From: Katie Kurek [REDACTED] **On Behalf Of** CCD Planning Consultations
Sent: 18 October 2017 15:15
To: Planning.Responses
Cc: Ian Buckland
Subject: RE: Planning Consultation on: LU/310/17/PL

**WEST SUSSEX COUNTY COUNCIL
PLANNING SERVICES CONSULTATION**

SUBJECT: LU/310/17/PL - Conversion of terraced house into 1 No. 3 bed house & 1 No. 2 bed house (resubmission following LU/359/16/PL).

93, East Ham Road, Littlehampton, West Sussex, BN17 7BQ

Proposed Block Plan

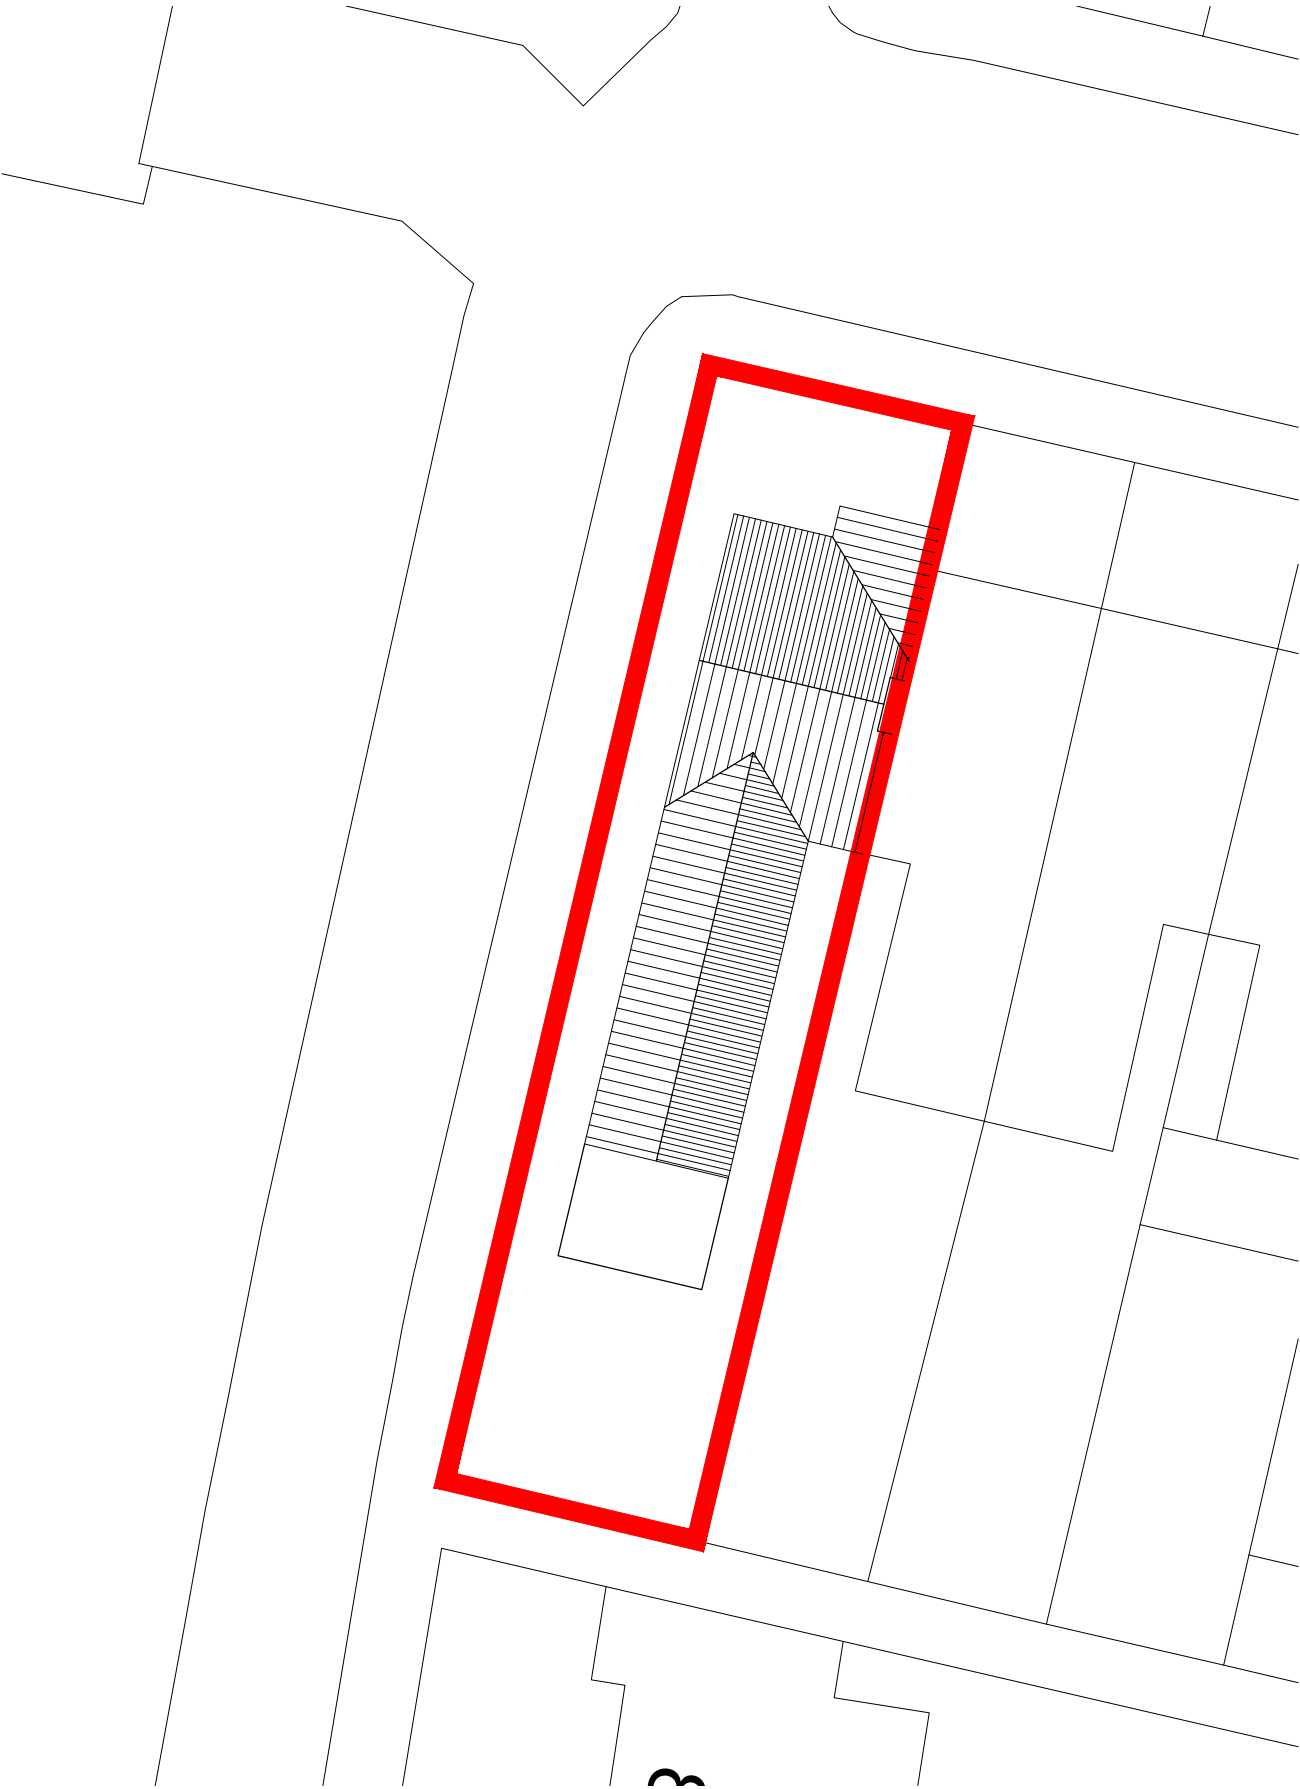
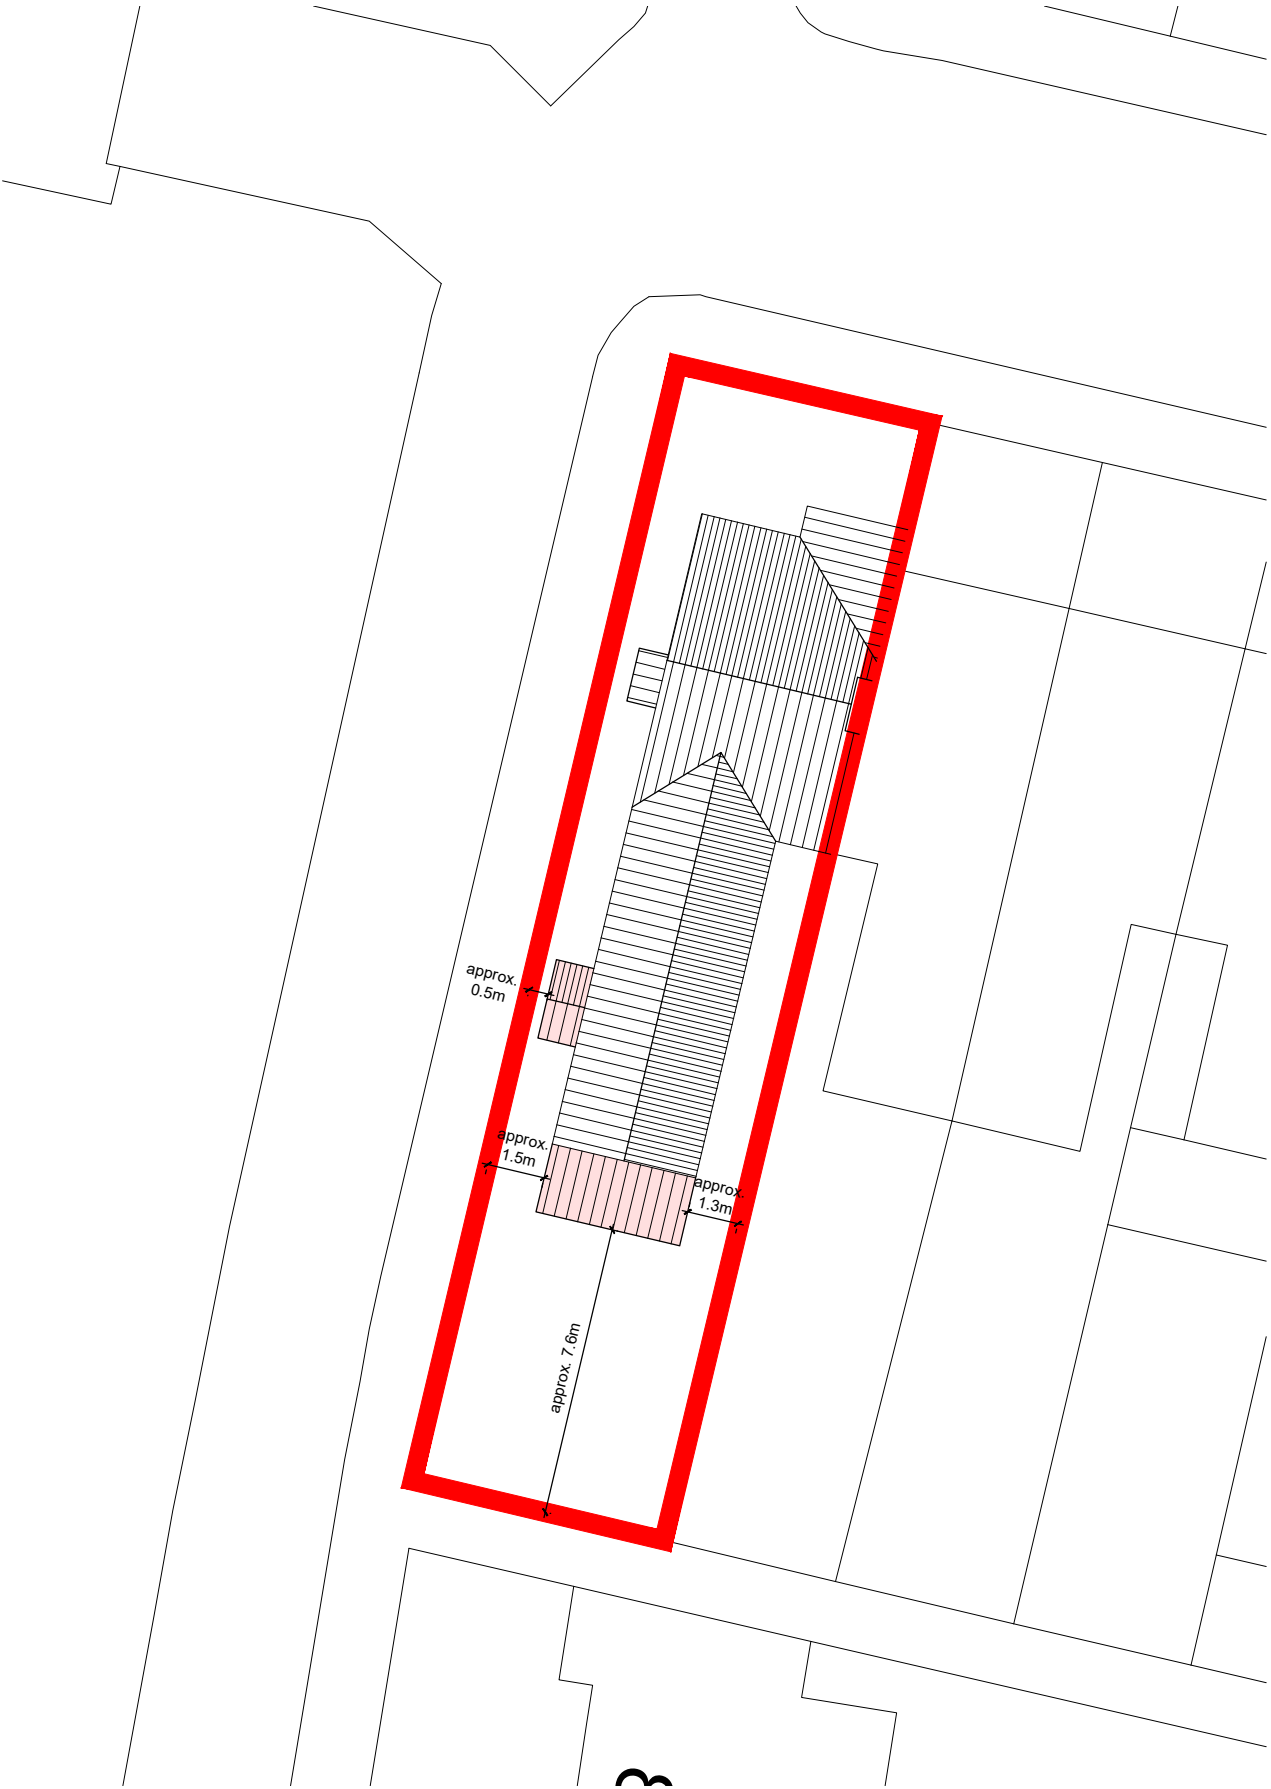
The current proposal is a resubmission to alter the description from 3-bedroom apartment to 3-bedroom house. The changes would not alter our previous advice though the LPA should be aware that whilst a nil car parking provision is proposed the development could see a demand for 3 spaces. We do not consider this highway safety grounds to resist the proposals though the LPA may wish to consider the amenity aspects and impact on on-street parking.

No part of the development shall be first occupied until covered and secure cycle parking spaces have been provided in accordance with plans and details submitted to and approved by the Local Planning Authority.
